Our Case Number: ABP-314724-22

Re: Railway (Metrolink - Estuary to Charlemont via Dublin Airport) Order [2022]
Metrolink. Estuary through Swords, Dublin Airport, Ballymun, Glasnevin and City Centre to Charlemont,
Co. Dublin

Estuary Court Submission No. 1

**Re-alignment of Metrolink Route Out
of Established Family Housing
Estates onto R132 Dual Carriageway**

Project	Drawing Title	Drawing Status
Estuary - Seatown Landscape Layout Preliminary Design Issue		S4
Drawing N°	ML1-JAI-ARL-SC01_XX-DR-Y-00001	
Scales Original Size A1	1:1000	Sheet 1 of 3

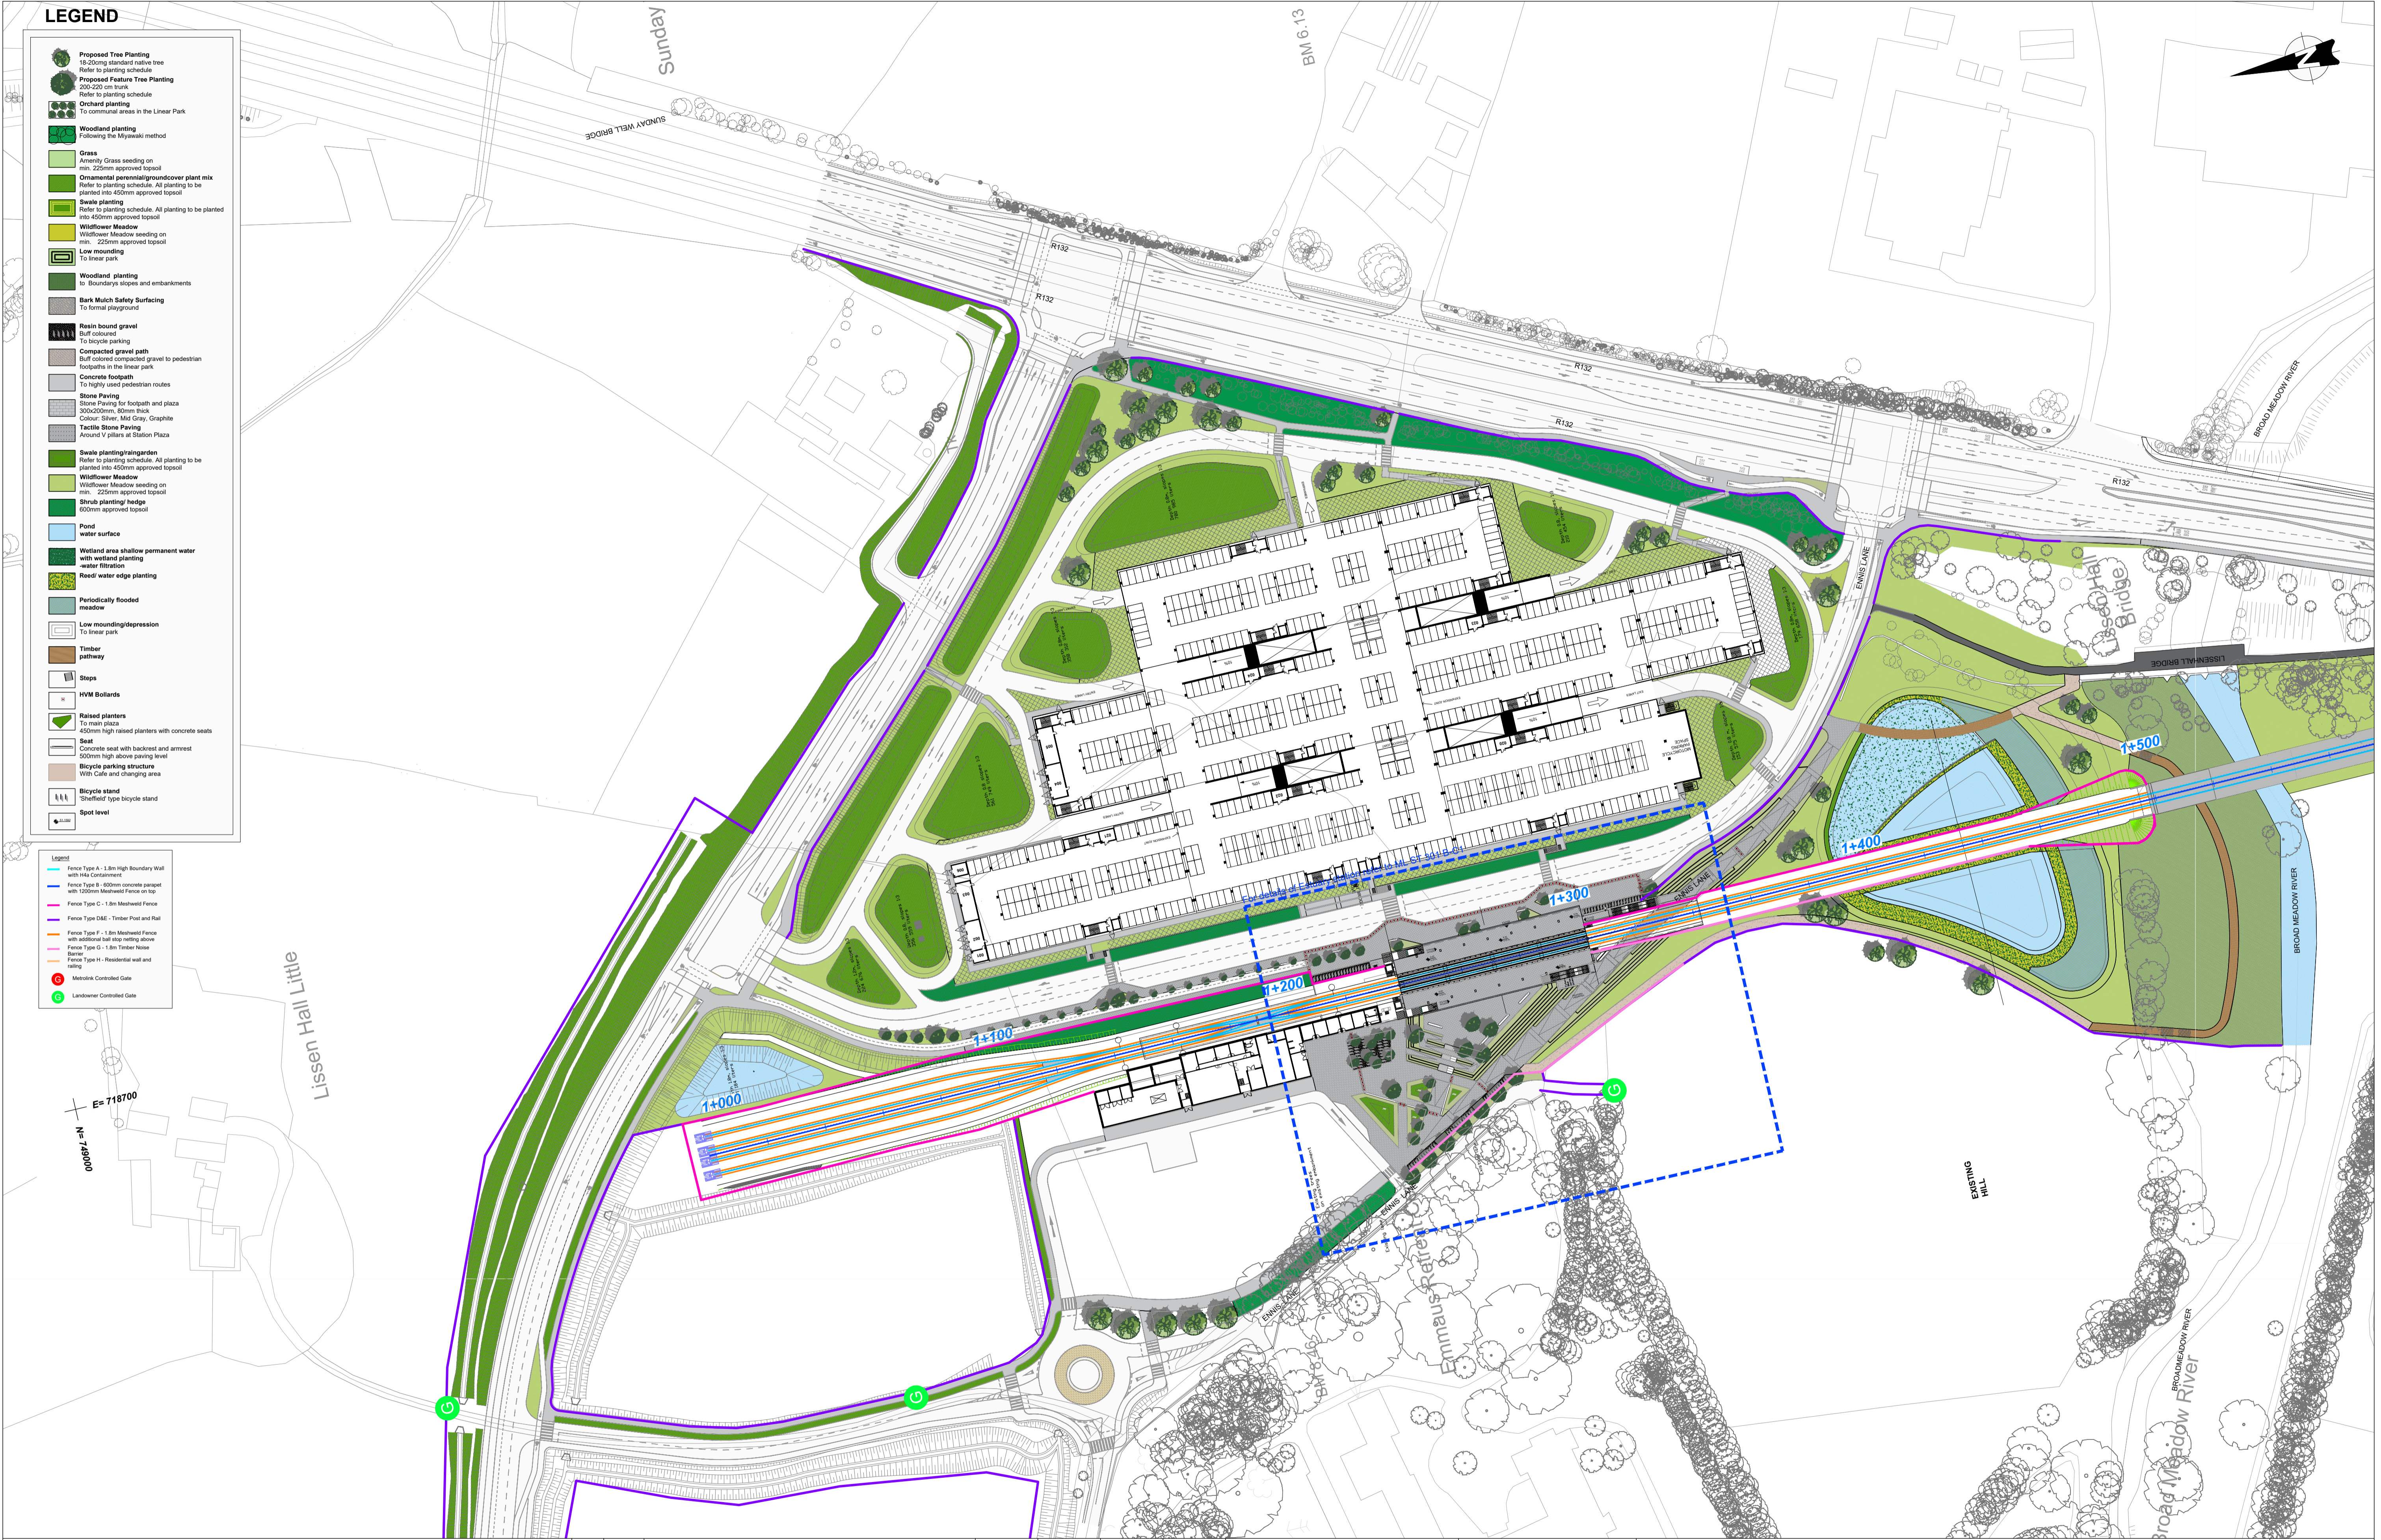
The current proposed Metrolink route cuts through the top green of Estuary Court. However, the TII plan to take both of our green spaces for the duration of the construction works. The top green for constructing the cut and cover tunnel through it, and the bottom green for a site compound. They also plan to demolish our boundary wall along the R132 and cut down the mature trees and landscaping along it.

The TII originally proposed not to reinstate our boundary wall. They wanted to take over our green spaces as part of a linear park. We have engaged with them on this over the last two years and the proposed plan in the Rail Order now includes for wall type H (not defined). However, they have included access gaps in the wall which makes it ineffective for security and the safety of our children playing on the green. Please see our Submission No. 2 for further detail on this.
